WEST SUSSEX COUNTY COUNCIL CONSULTATION

TO:	Arun District Council FAO:Ms Myer
FROM:	WSCC - Highways Authority
DATE:	14 July 2020
LOCATION:	Land north of Springfield House Cross Road Rustington BN16 2ST
SUBJECT:	R/102/20/PL 1 No. detached 5-bedroom house with attached single storey double garage & carport.
DATE OF SITE VISIT:	n/a
RECOMMENDATION:	Advice
S106 CONTRIBUTION TOTAL:	n/a

Drawing
Proposed ground floor plan

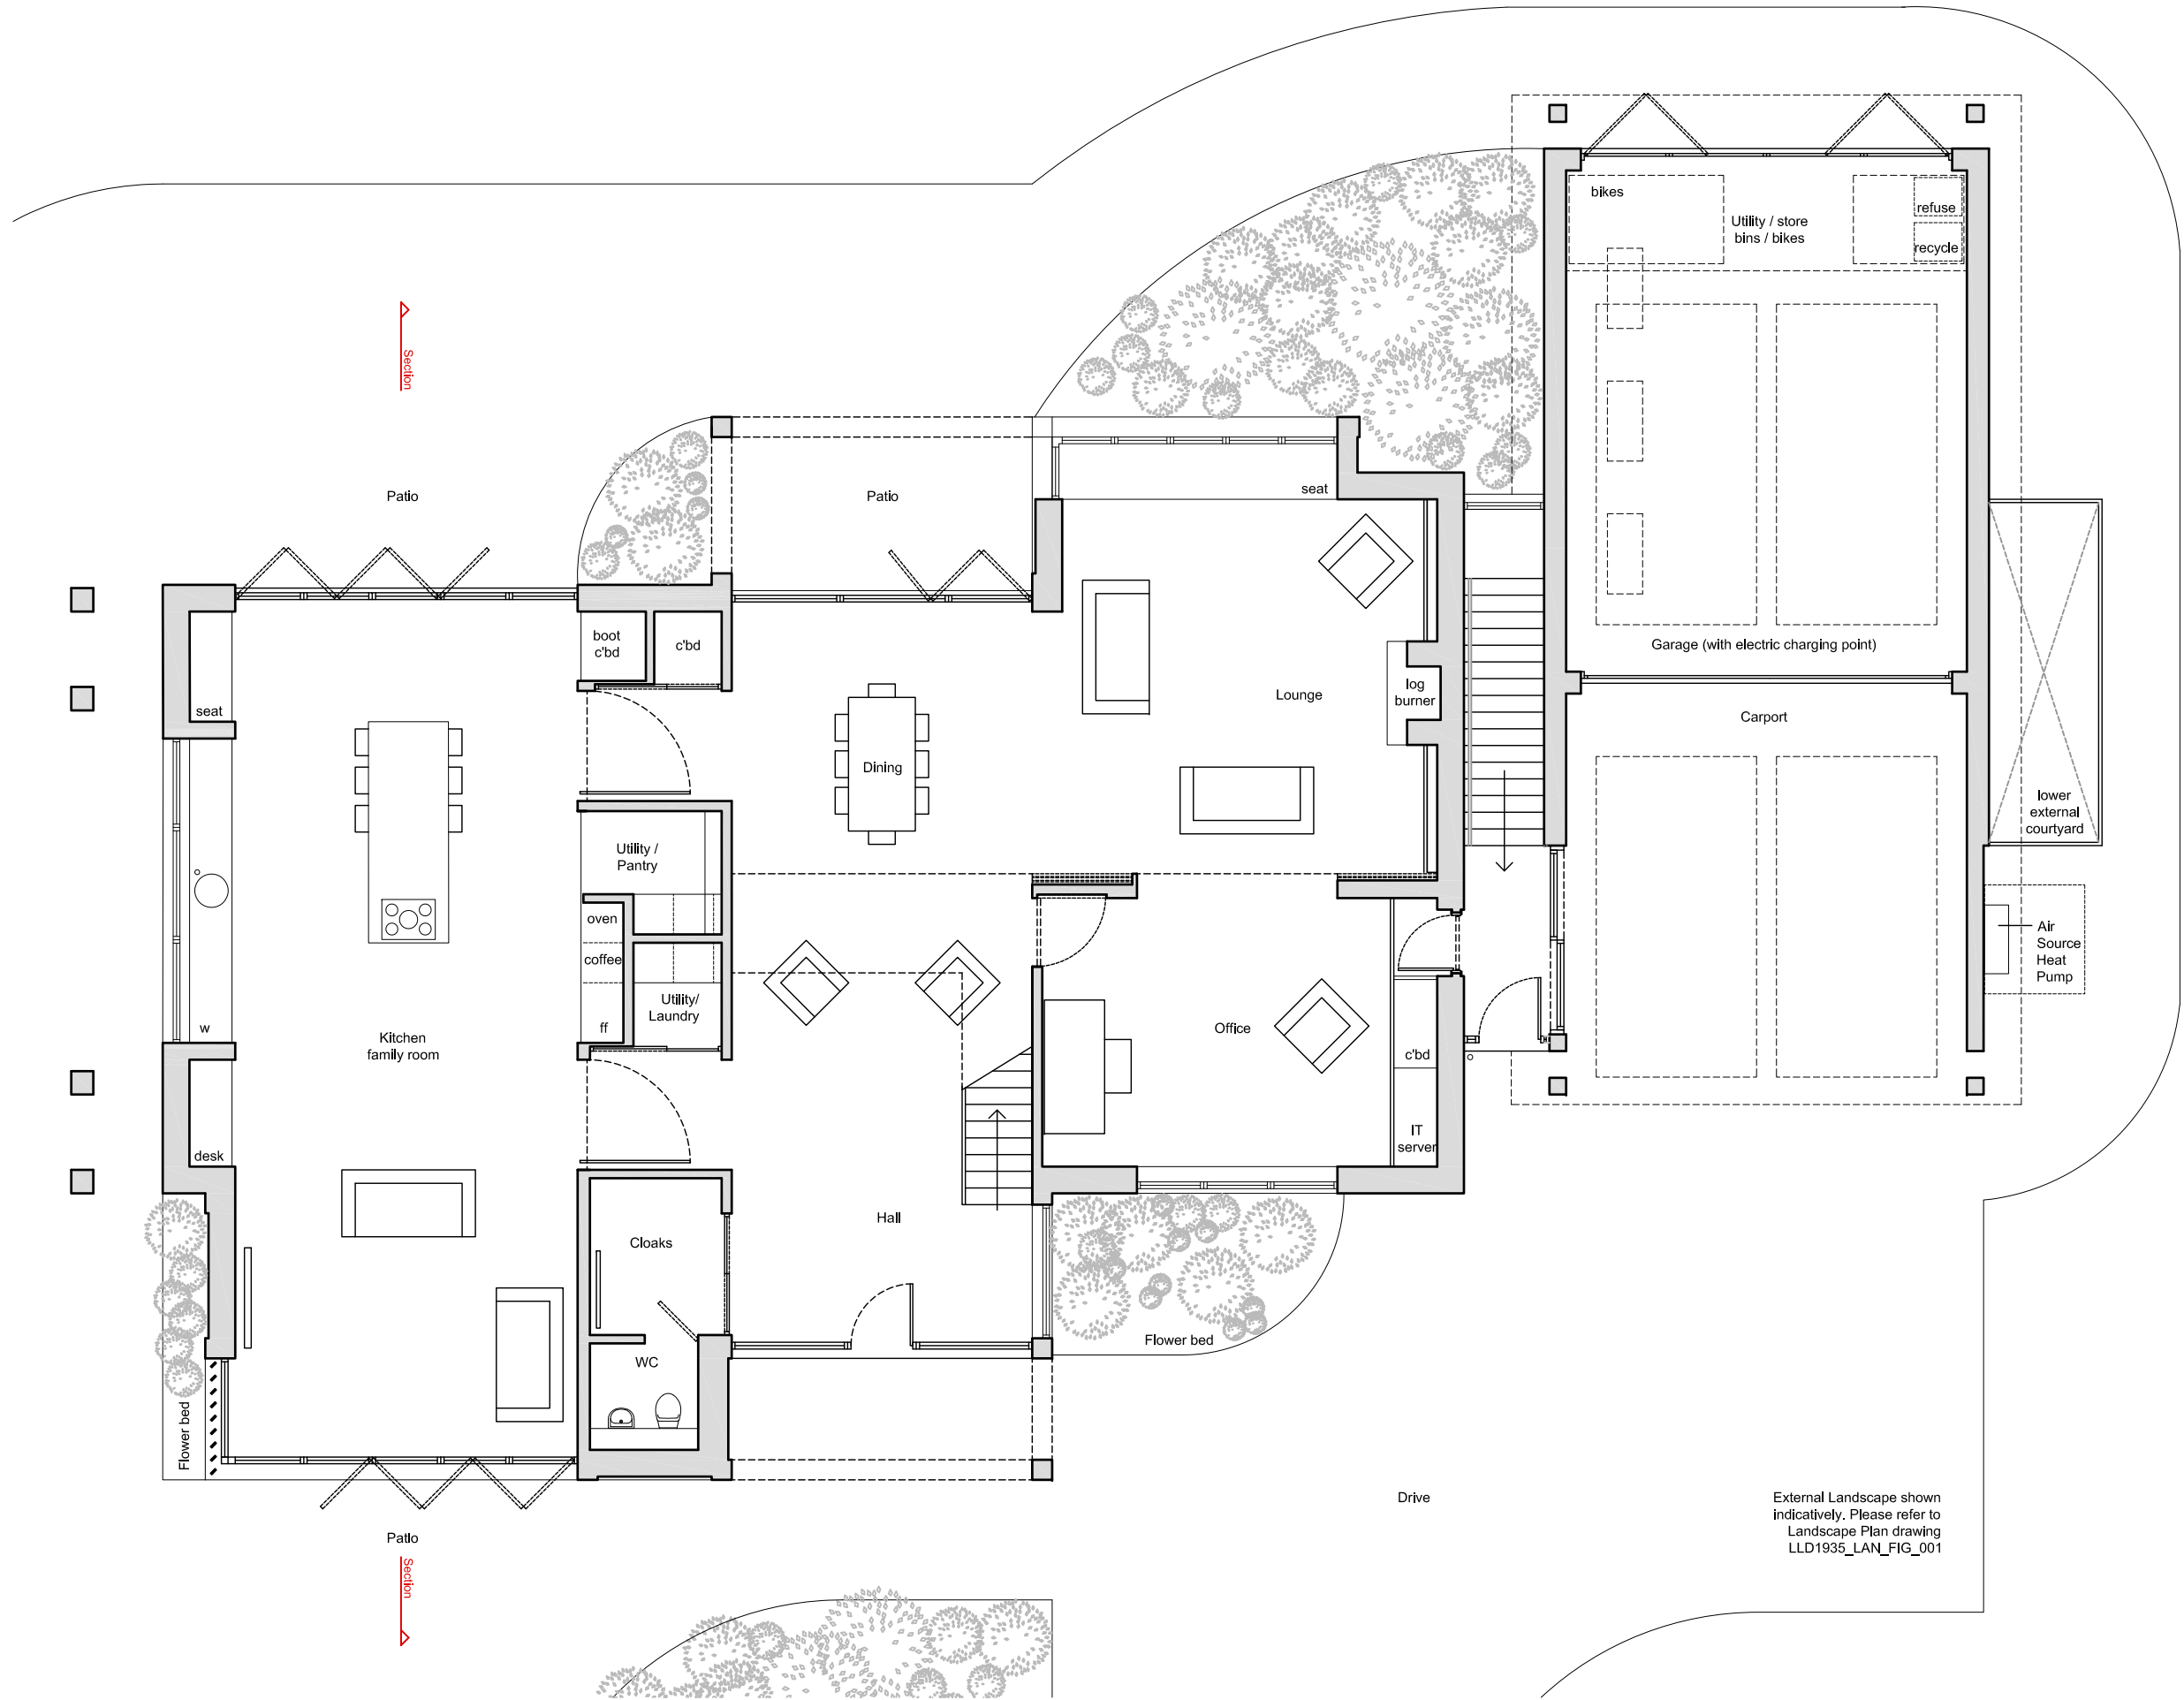
Onsite parking provision will be provided within the proposed garage, car port and the hardstanding area. The proposed garage measures circa 6 x 7.5m internally and this would be adequate to accommodate 2 vehicles including space for cycle storage. The proposed car port also has the adequate dimensions of at least 2.4 x 4.8m per parking bay as outlined in Manual for Streets guidance. The WSCC Car Parking Demand Calculator (PDC) would expect at least 3 parking spaces (on unallocated basis) for 4+ dwelling in this location. Under the revised WSCC parking guidance, each garage space (3 x 6m) counts as 0.5 of a parking space, and as such, each double

garage (6 x 6m) counts as one parking space towards the expected provision. The WSCC Parking Demand anticipates that the proposed parking provision is sufficient for this development.

The proposed plans annotate EV parking facility within the proposed garage. The Arun Car Parking standards states that in the interests of sustainability and as result of the Government's 'Road to Zero' strategy for at least 50% of new car sales to be ultra-low emission by 2030, electric vehicle (EV) charging points should be provided for all new homes. The applicant is advised that for dwellings with a garage and driveway, 100% of parking spaces should be provided with active EV parking spaces in accordance with the Arun Parking Standards (adopted January 2020). Details of this can be secured via planning condition.

The site is situated within a residential area in East Preston. In order to promote the use of sustainable transport methods, the LHA recommends that covered and secure cycle storage is provided for the dwelling. The proposed ground floor plan demonstrates space for cycle storage within the proposed garage and these details are acceptable.

No part of the development shall be first occupied until the car parking has been constructed in accordance with the approved proposed ground floor plan 2002 Rev 4. These spaces shall thereafter be retained at all times for their designated purpose.

No part of the development shall be first occupied until covered and secure cycle parking spaces have been provided in accordance with the approved proposed ground floor plan 2002 Rev 4.
